**WEST SUSSEX COUNTY COUNCIL
PLANNING SERVICES CONSULTATION**

SUBJECT: FG/198/16/PL

**Demolition of existing house with erection of 2 storey building comprising of
8No. residential 2 bedroom flats & associated external works.**

1, Sea Drive, Ferring, BN12 5HD

BASEMENT FLOOR PLAN

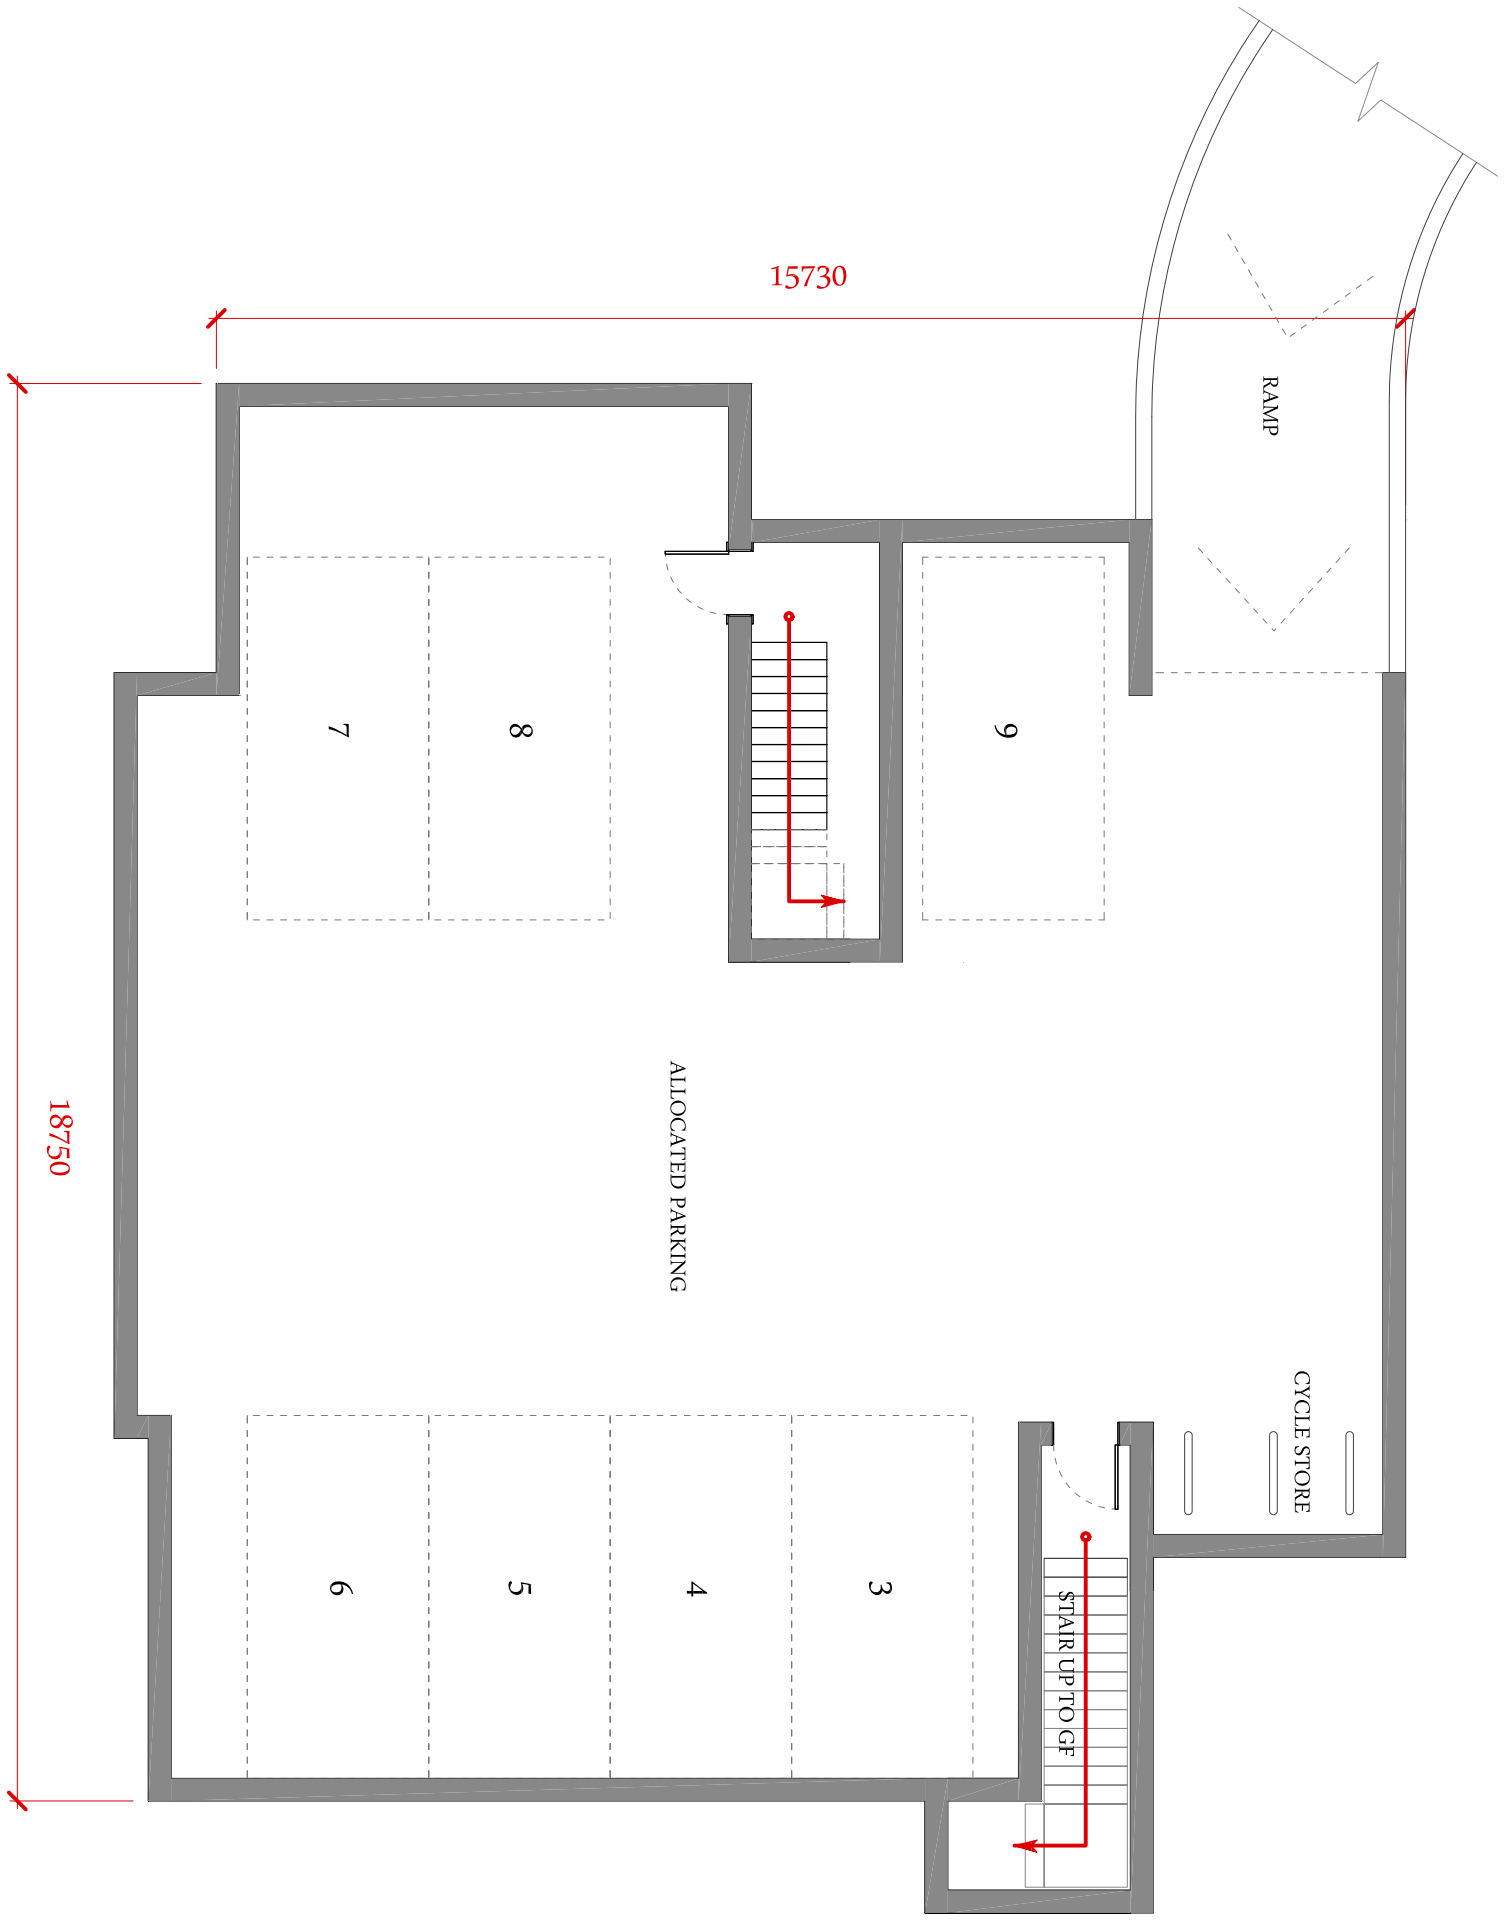
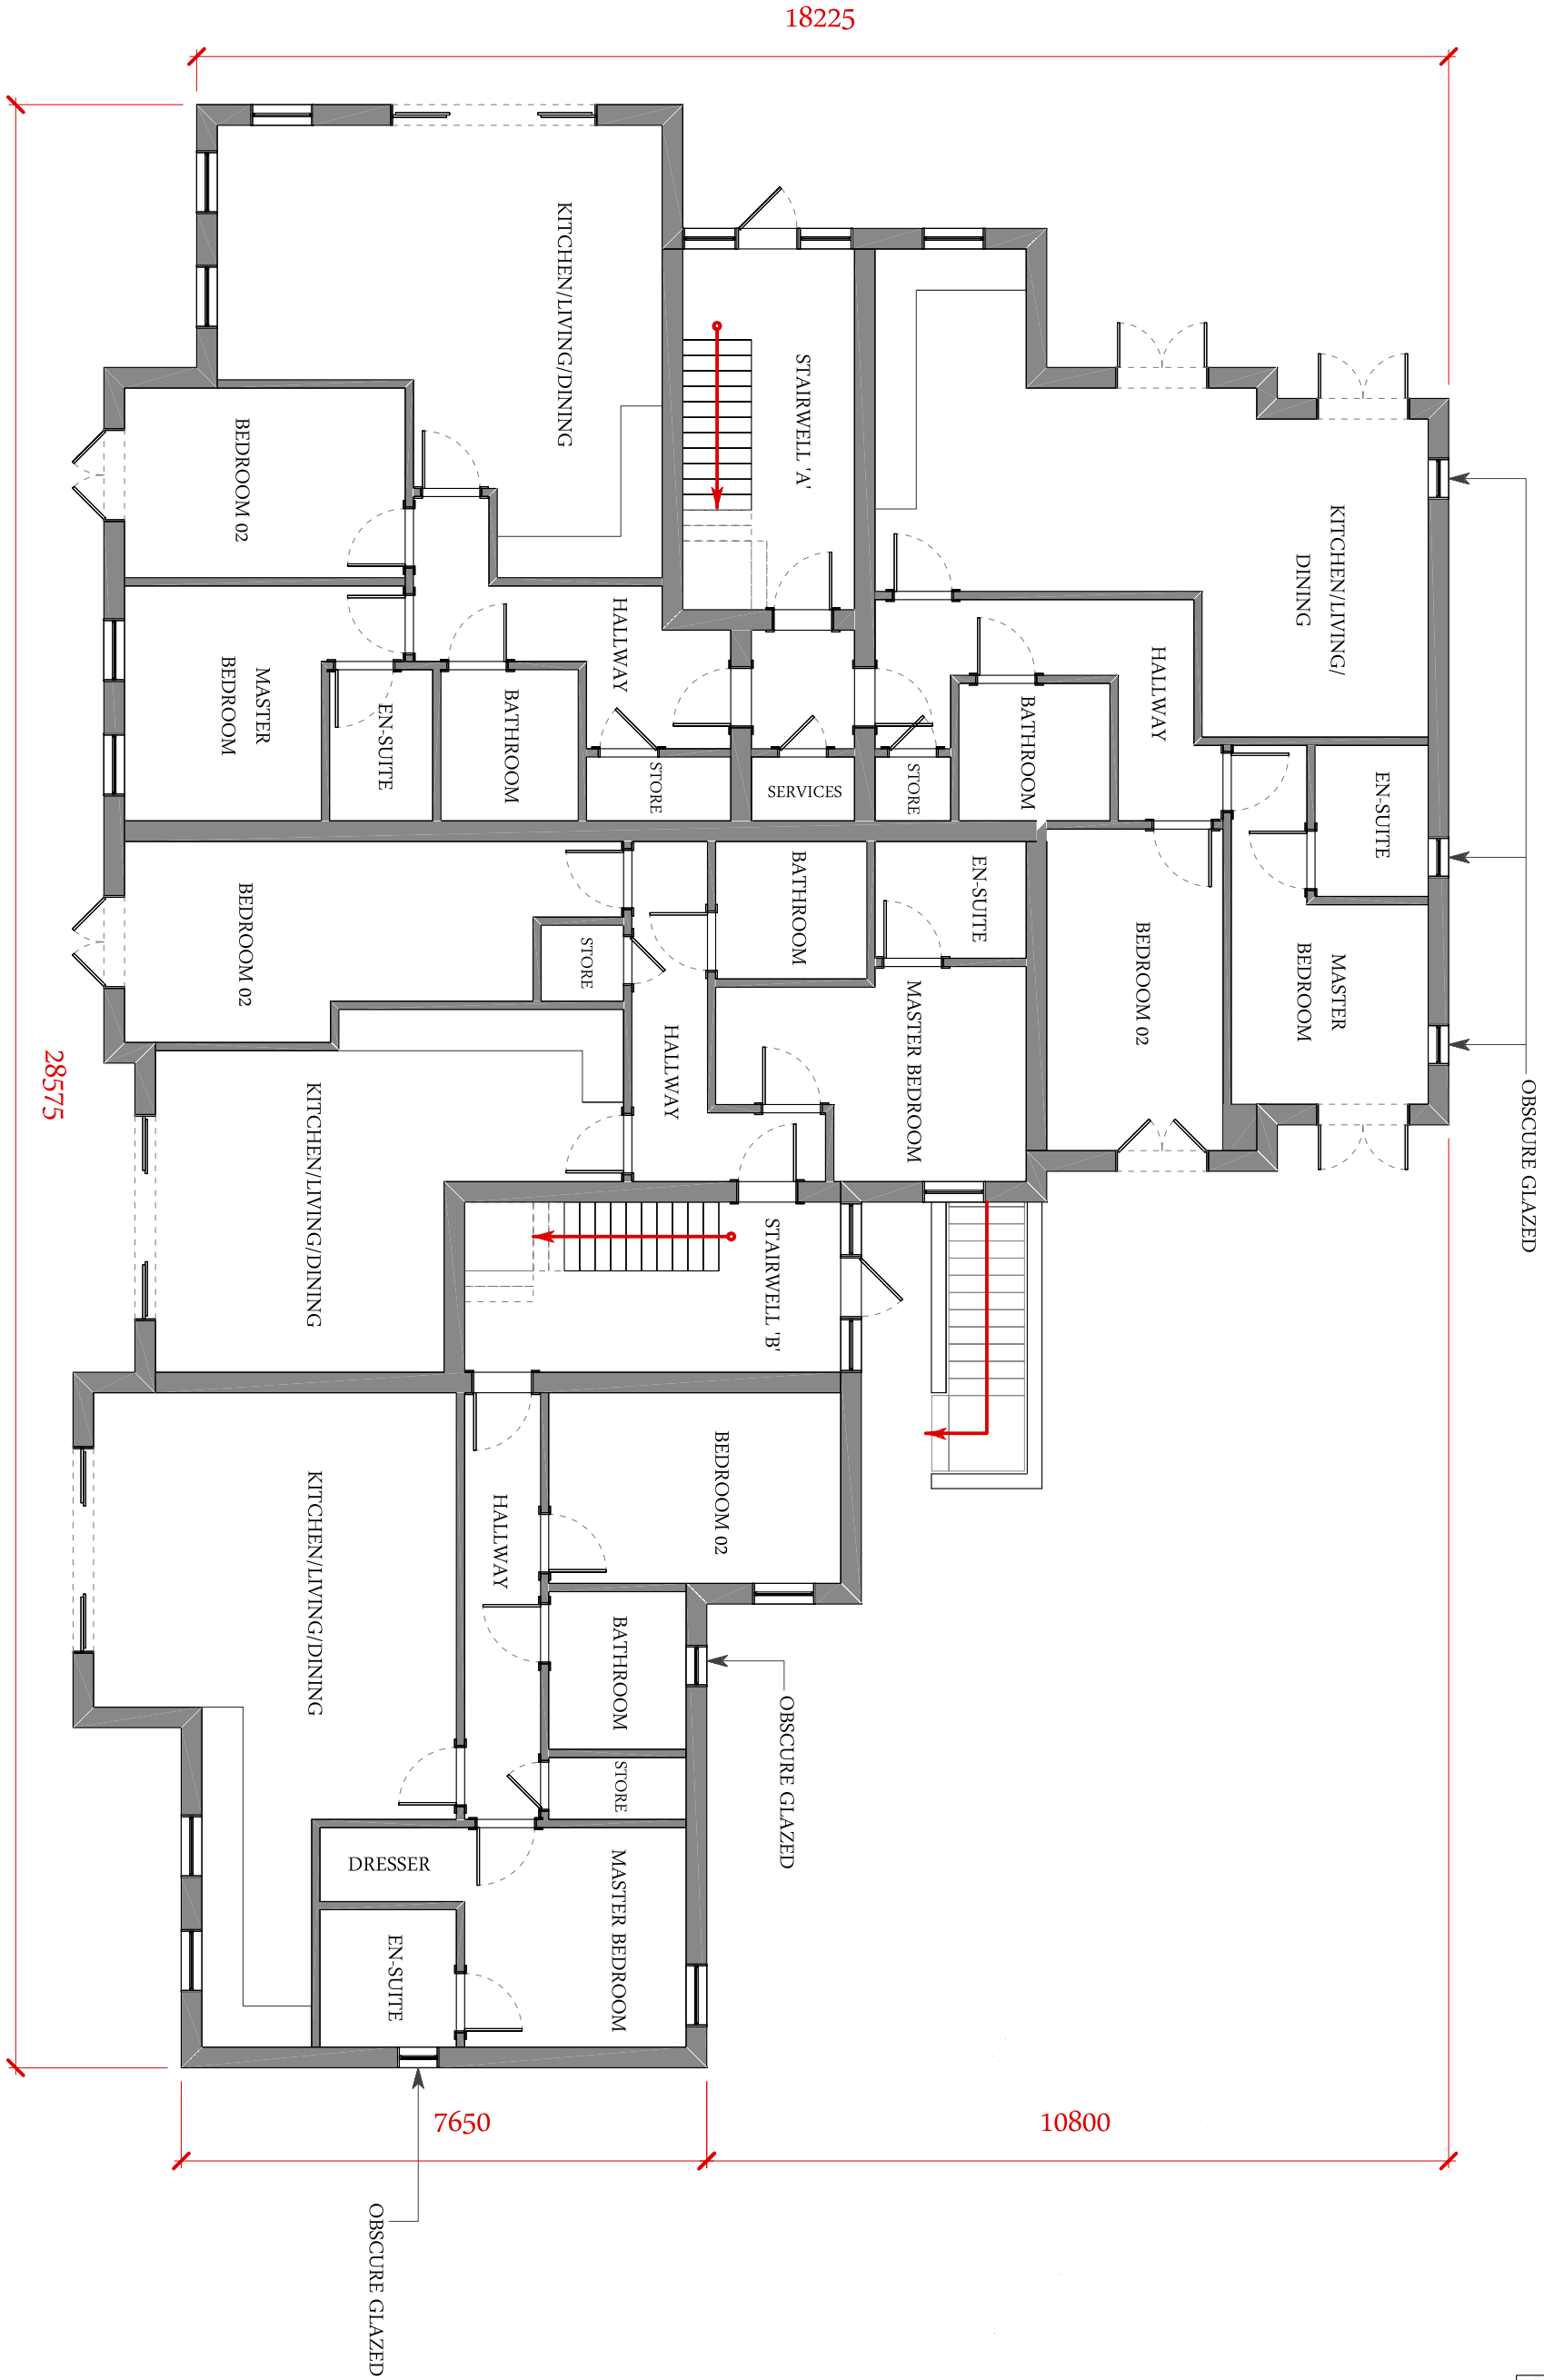
The proposed underground parking arrangement provides for seven spaces of car parking. The dimension of the bays are 2.4m x 4.8m, which accord with the minimum parking bay dimensions as set out in the WSCC Parking Standards. An aisle width of 6m is used, and the arrangement is consistent with the Department for Transport publication 'Manual for Streets' perpendicular parking arrangement (figure 8.18, page 11). The LHA is satisfied that the proposed arrangement is consistent with national design guidance.

Should a driver enter the underground parking area whilst all seven spaces are occupied, drivers will be able to utilise the space at the end of the ramp in order to turn and exit in forward gear. The LHA have tracked the manoeuvre and it can be undertaken as a 3-point turn. There is clear inter-visibility between drivers entering the ramp and a driver undertaking the turning manoeuvre to allow sufficient space to be provided for the driver to complete the turn. The Applicant should ensure that the space at the end of the ramp, adjacent to the stairwell, is suitably marked to so that it is kept clear of parked vehicles.
